ADDENDUM #4

**Iris Park Apartments L.P.
Portland, Maine**

RE: Addendum No. 4 to the Bidding Documents for:

This Addendum forms a part of the Contract Documents and modifies the original Bidding Documents dated March 21, 2005.

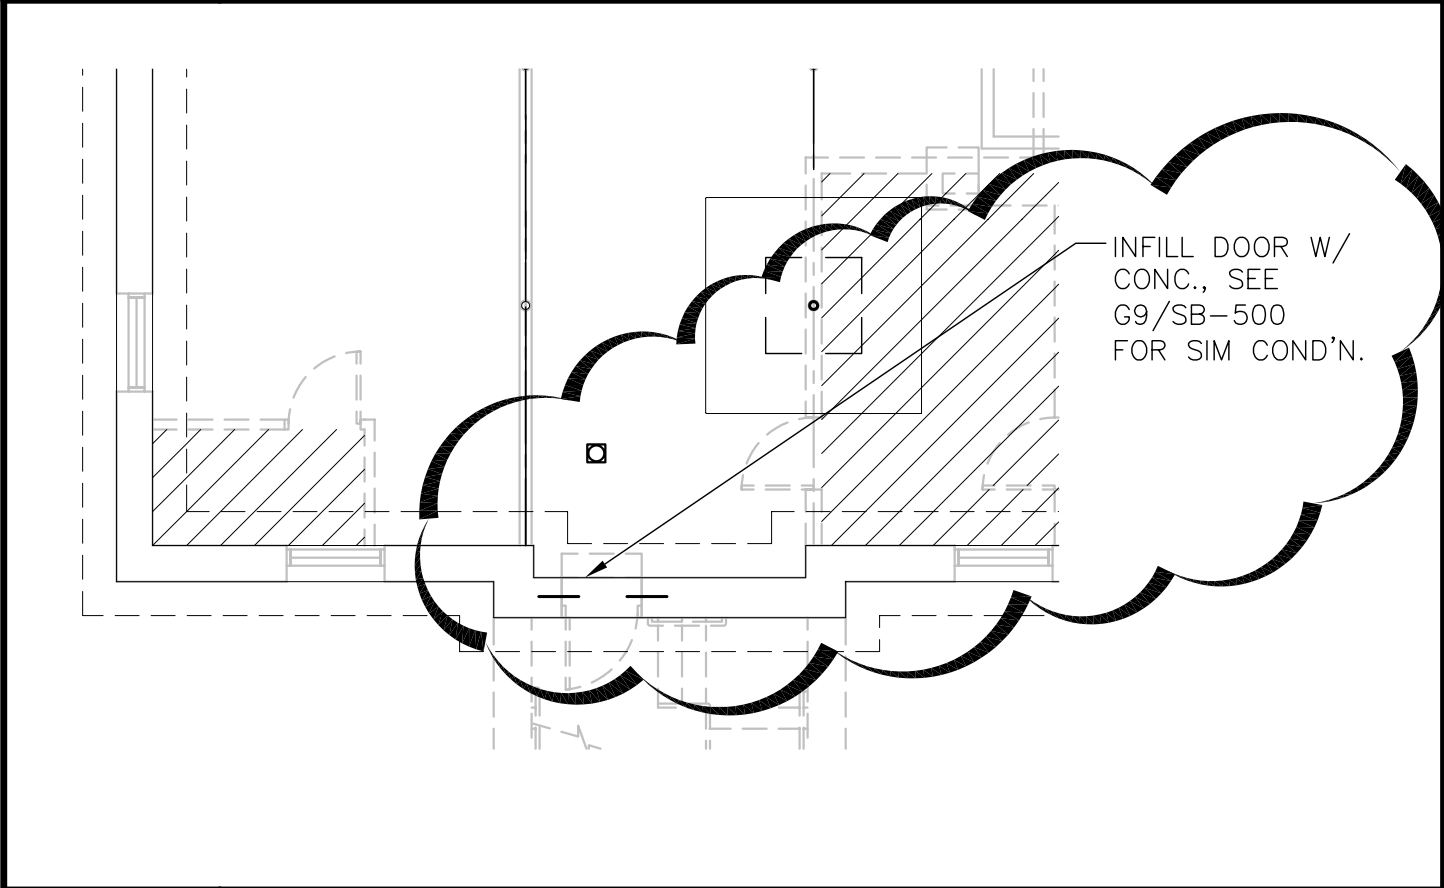
SKS-07 – Wall repair/ infill at existing foundation

SKS-08

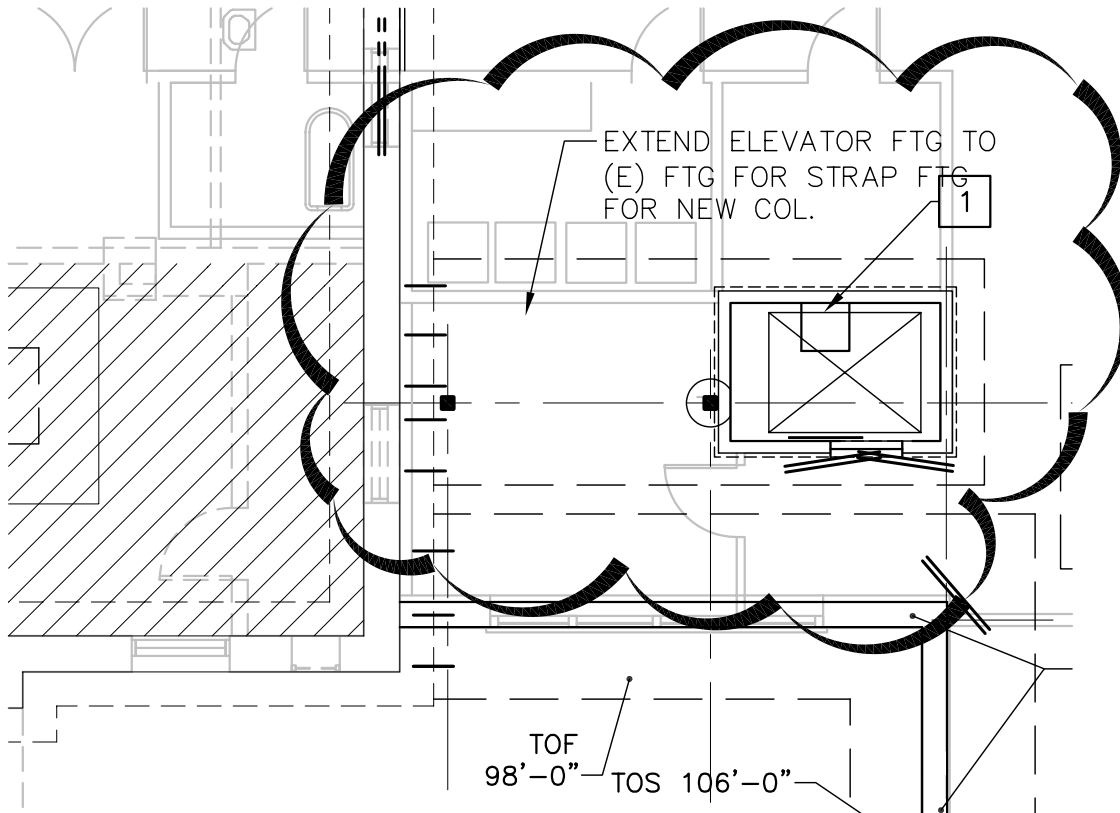
SKS-08 – Strap footing at new column by Elevator
